From: Philip Woolger [REDACTED]
Sent: 02 November 2020 16:32
To: Kathryn Welch <Kathryn.Welch@arun.gov.uk>
Subject: RE: 8 Fernhurst gardens.

-The porch is slightly too large, to be covered by PD rights the maximum allowance is 3m² and your proposal currently measures at 3.84m² can you adjust this on plans 010 and 003.

26'~8.m

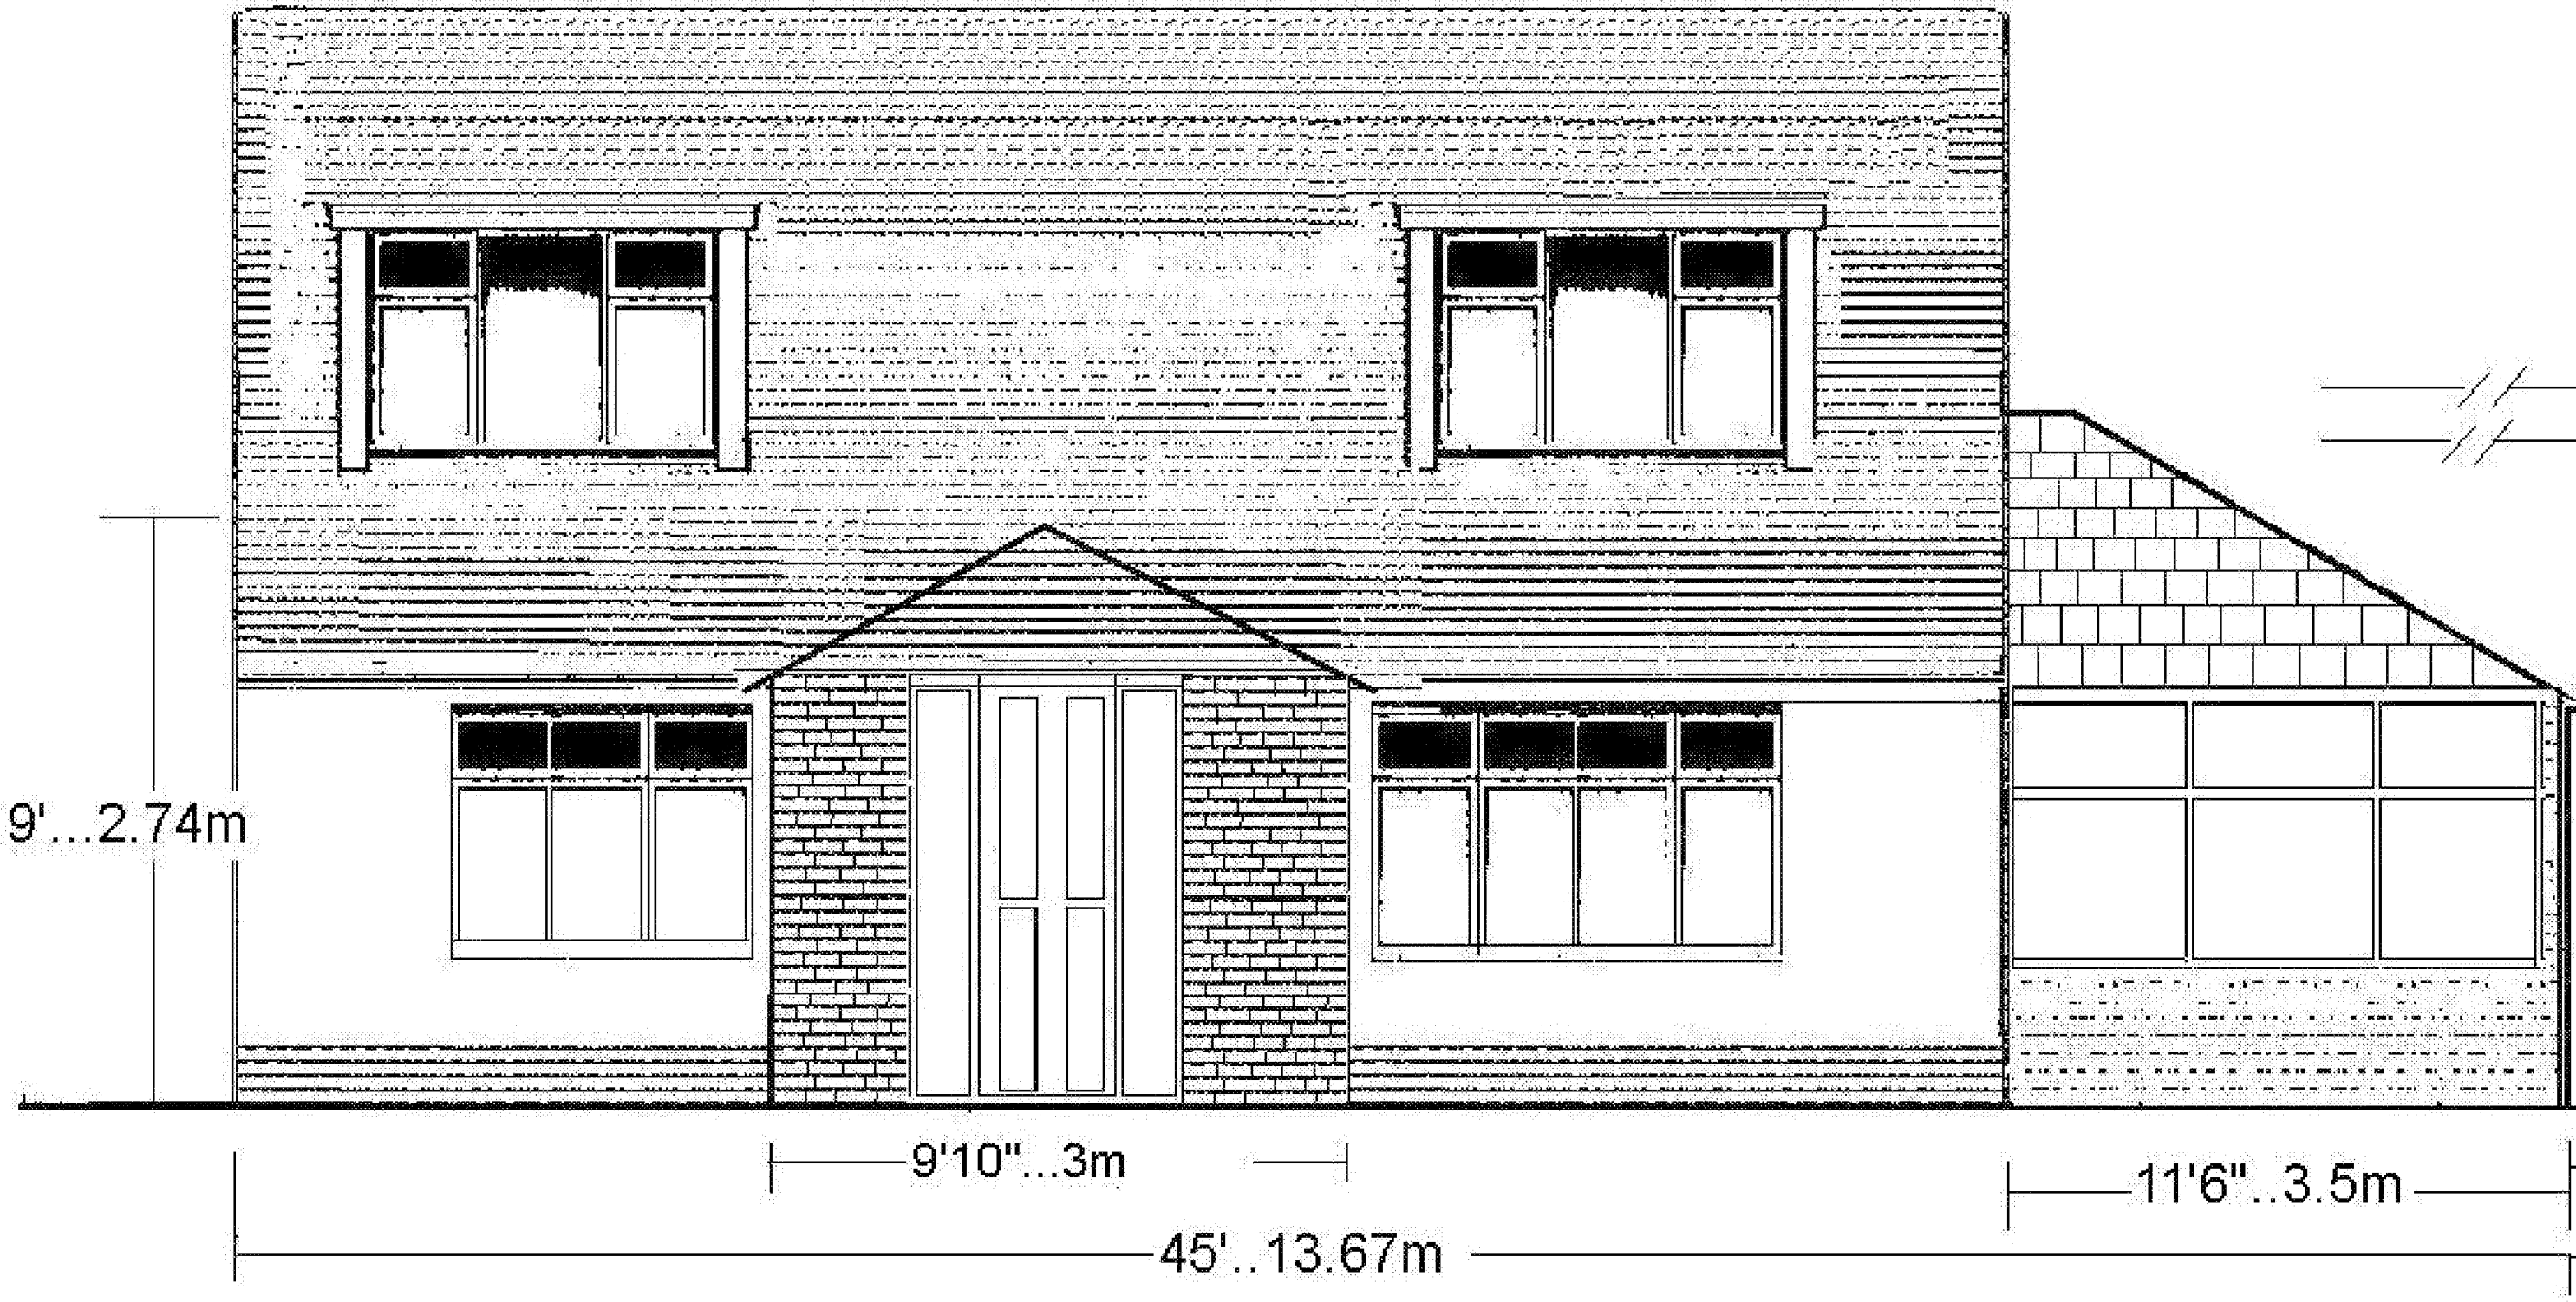
Can I get your permission to alter the description of the application, to include mention of the hardstanding in front of the garage please?

porch 3m x 1m ...2.2m to eaves.....Antique red Marley plain tile 265 x 165mm as per existing building.....and Block paved driveway (we were planning on this)just missed it off. We understand about the drain off on solid concrete.

Attached drawing 003...and 010...adjusted .
